Outer Dowsing Offshore Wind

Schedule of Changes for Plans

Procedural Deadline 19 September

Document Reference: 2.0

2.18 Onshore Crossing Plan

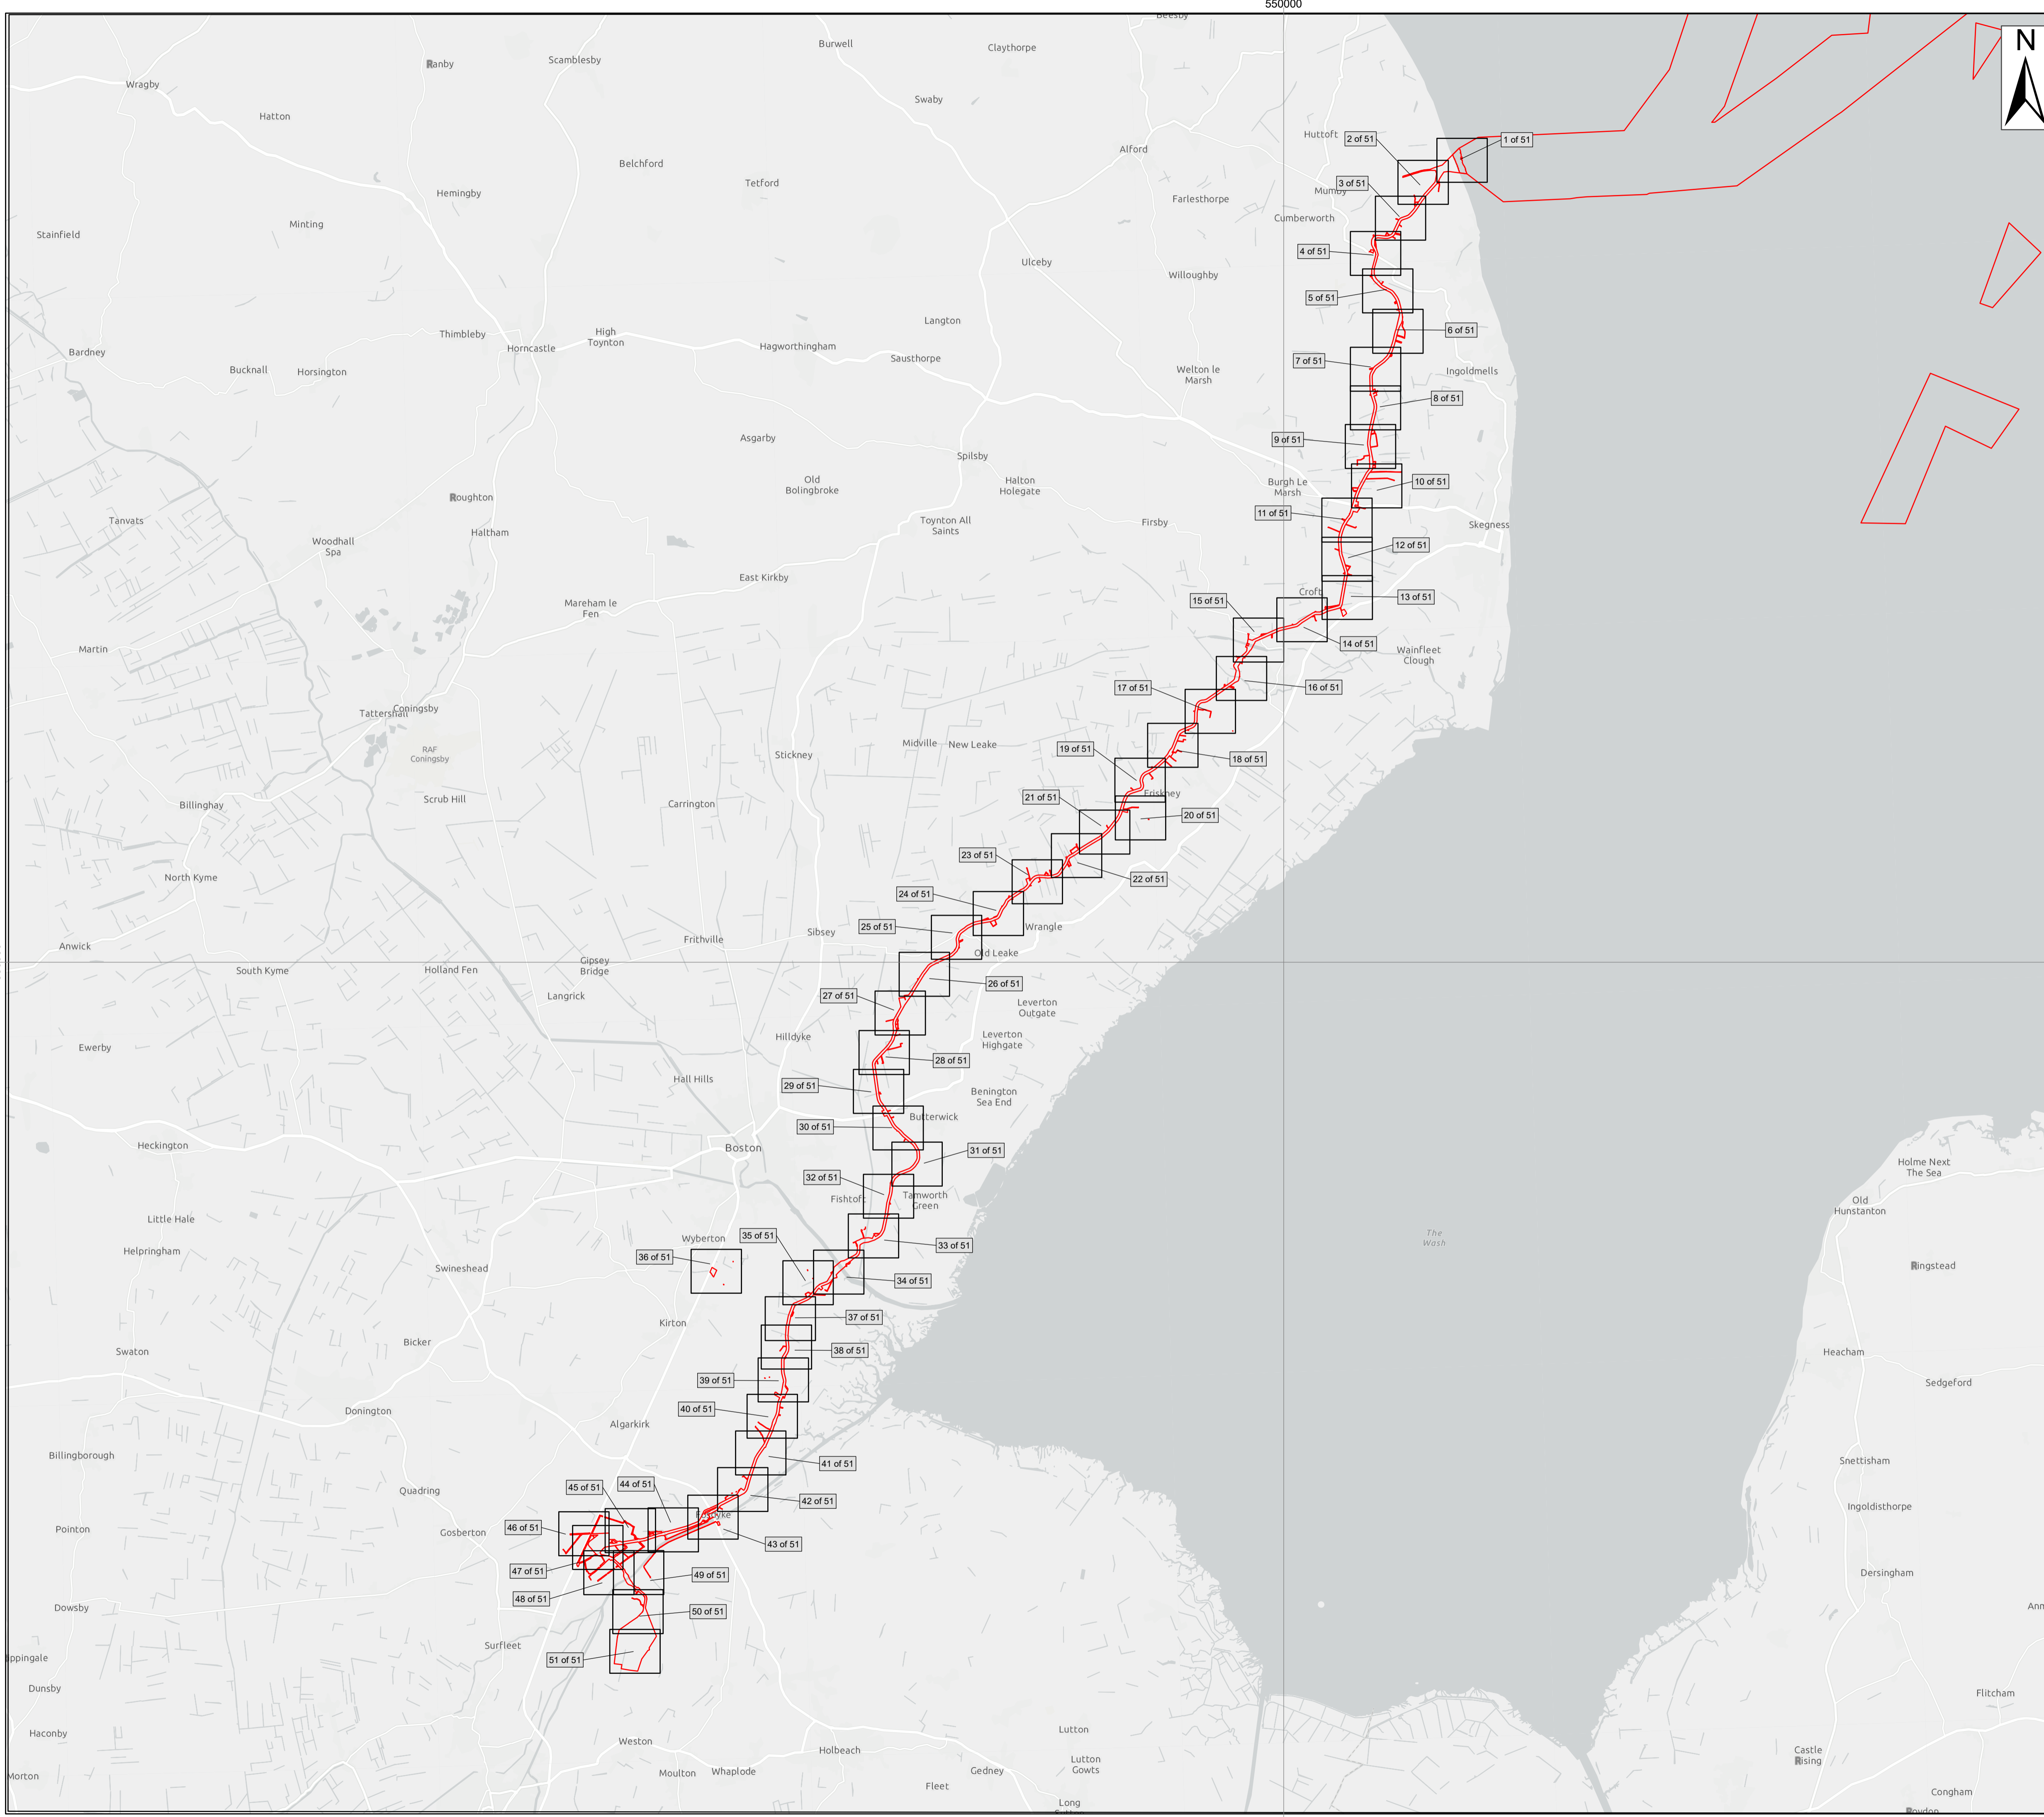
5. The Onshore Crossing Plan (document 2.18) has been updated following consultation with National Gas Transmission to include a pipeline that was not shown previously and which was not on the utilities dataset used for Application. This has been added to both the Onshore Crossing Plan (Sheet 49) and the associated Crossing Schedule as UUX-250a (document reference 6.3.3.2) updated for this deadline.

6. The Onshore Crossing Plan (2.18) and Public Rights of Way Plan (2.10) have been updated to show proposed new public rights of way (PROWs) identified through consultation with Lincolnshire County Council (identified by their Boston Borough Council planning application reference numbers), along with the indicative routes for diversions. These proposed new PROWs have also been included in the associated Crossing Schedule (6.3.3.2). The proposed new PROWs and associated diversions (as appropriate) are shown on the following sheets of the Onshore Crossing Plan by reference to the crossing (PRX) or diversion reference (PRDX) and on the Public Rights of Way Plan by reference to the planning application reference number:

### 2.1 Onshore Works Plans

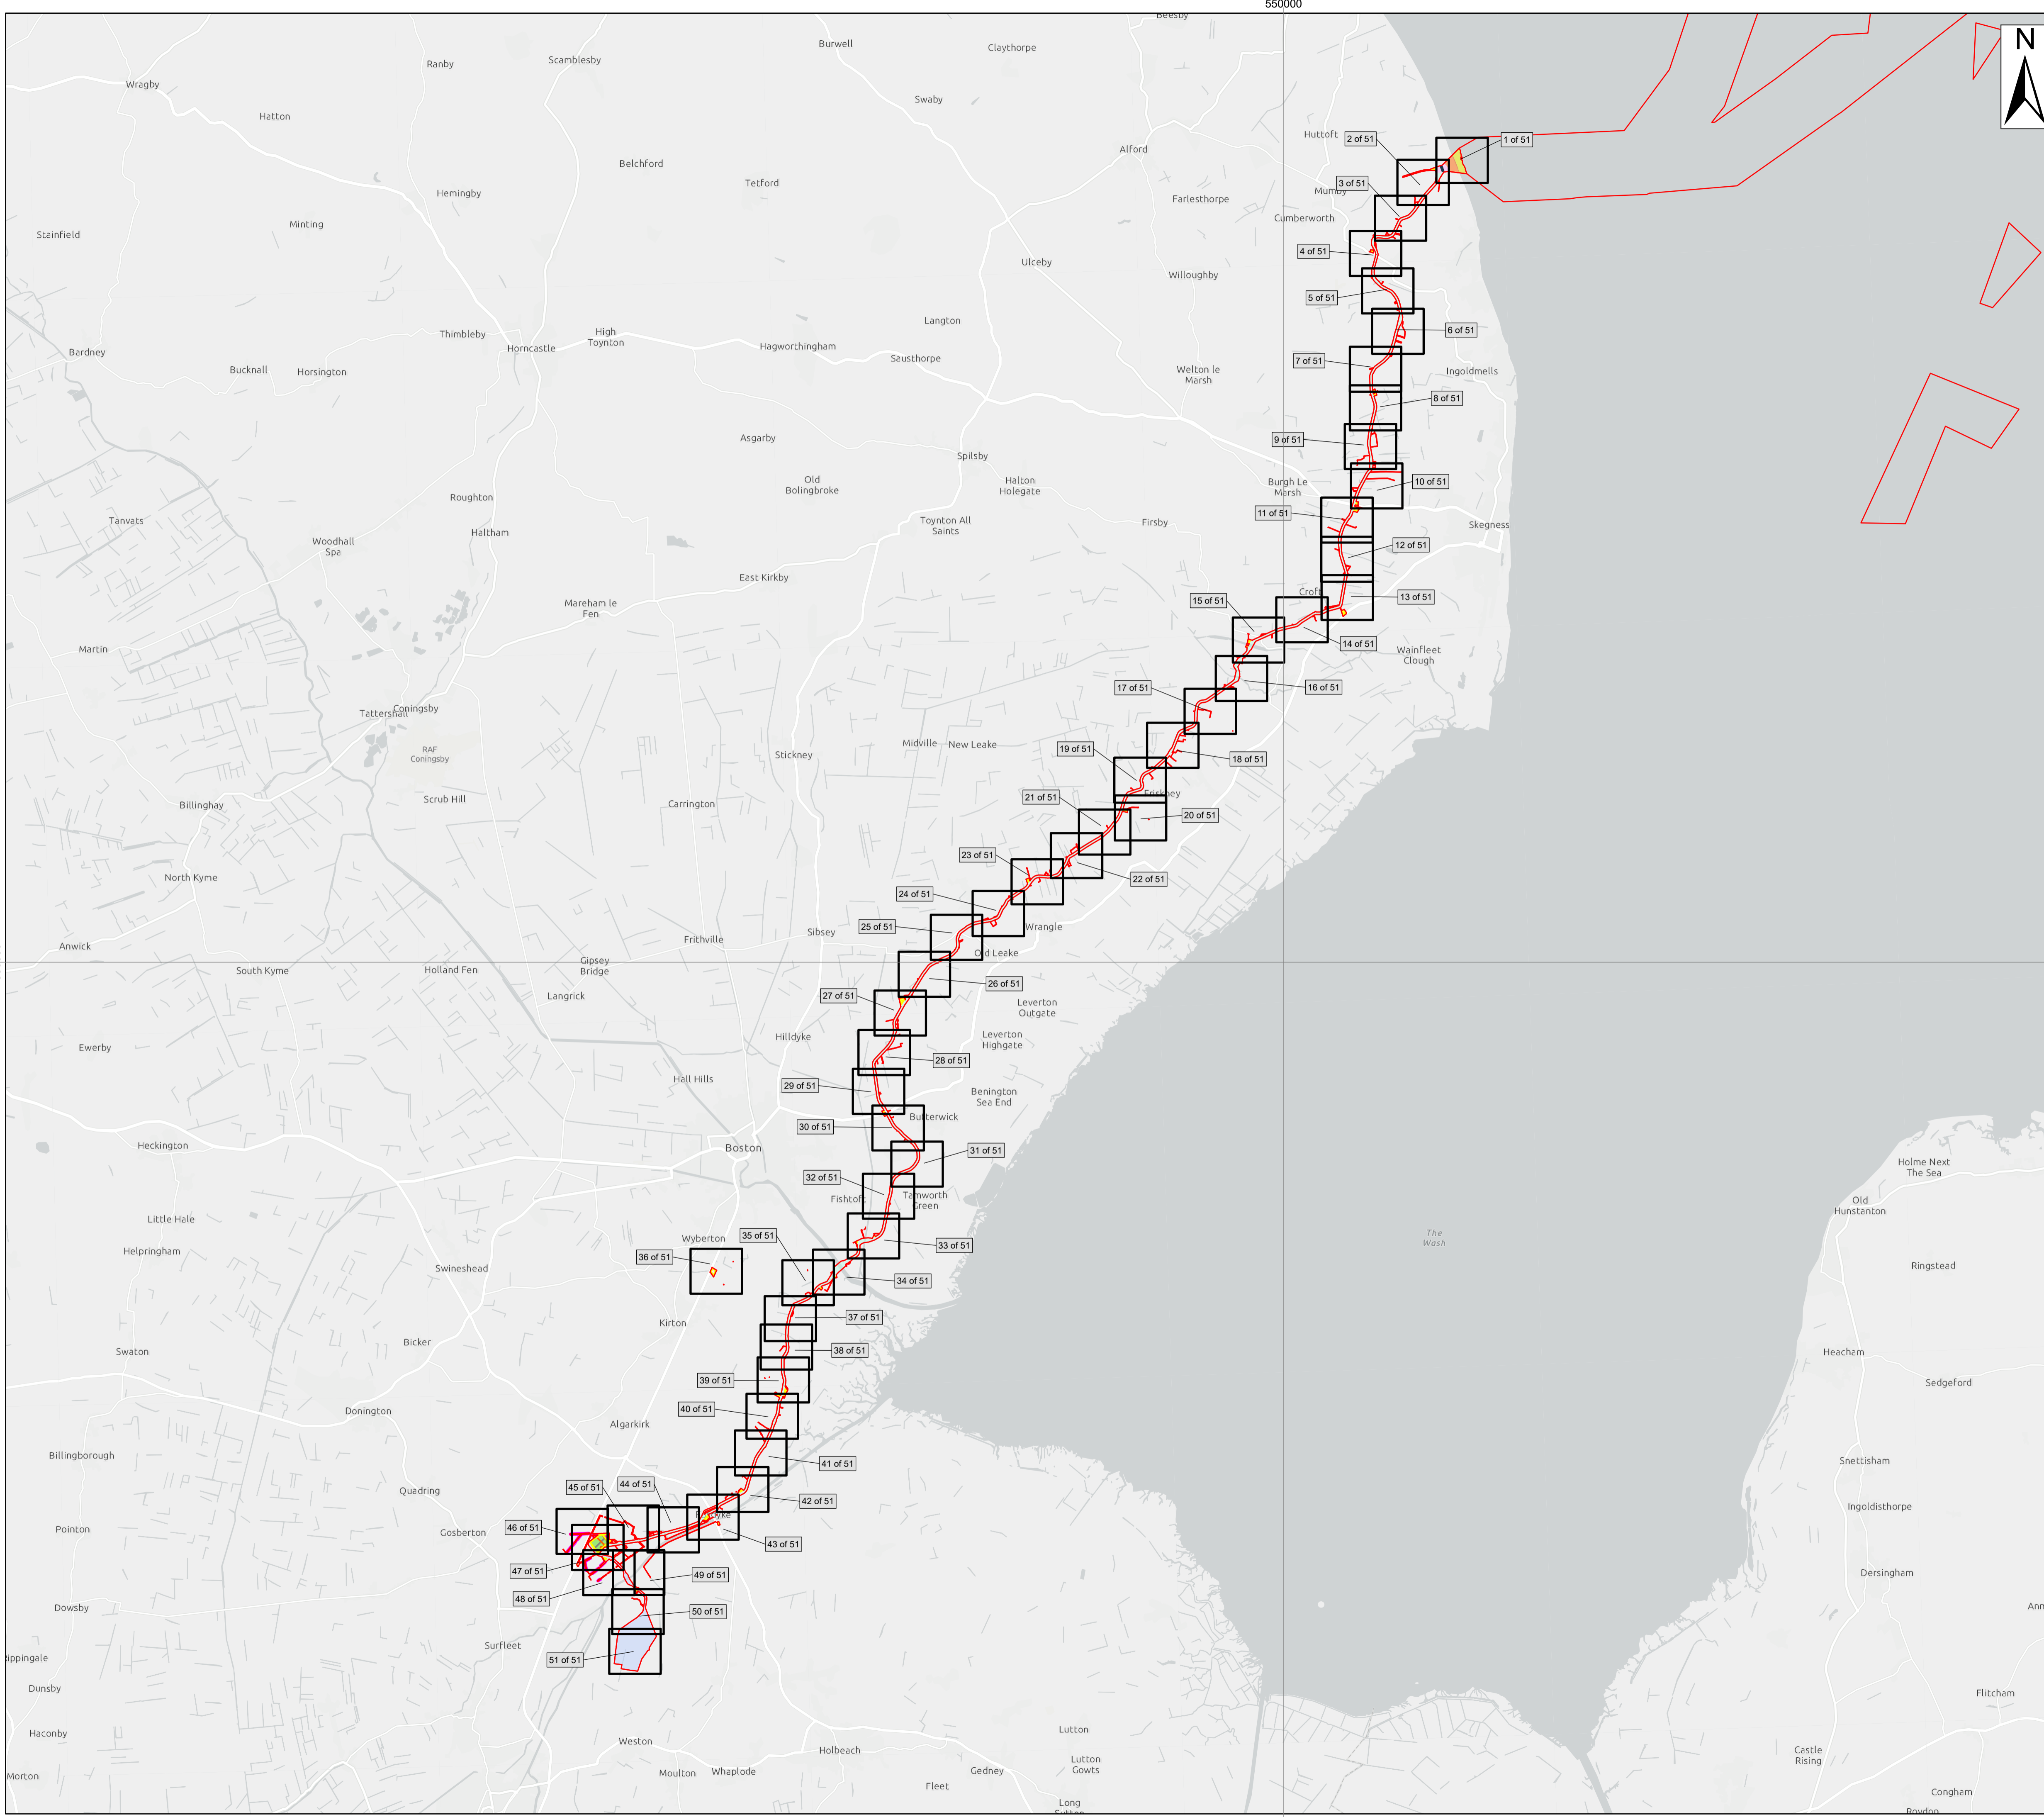
2.1 Works Plan Onshore						
2.1		N/A	September 2024	V3	Updated to reflect refined Order Limits	Order limits refined to remove enabling and permanent accesses which are no longer required. These changes are on sheet 35 and 46.

2.1		N/A	September 2024	V3	Updated to reflect refined works areas	Works areas refined around access bellmouth at the OnSS to account for a third party planning application. The change includes a reduction in landscaping (Work No. 23) and replacement with drainage works (Work No. 24). These changes are on sheet 47.

2.1		N/A	September 2024	V3	Updated to reflect refined works areas	West of the A16, works areas refined to reduce landscaping width from 10m to 6m (Work No. 23). The remaining 4m width is now presented as areas for drainage works (Work No. 24). This change has been

Plan Numbers	Reference	Plot Number(s) if appropriate	Date of Change	Revision Change	Change Made	Reasons for Change
						made to allow access to the ditch for maintenance and jetting of land drains. These changes are on sheet 46.
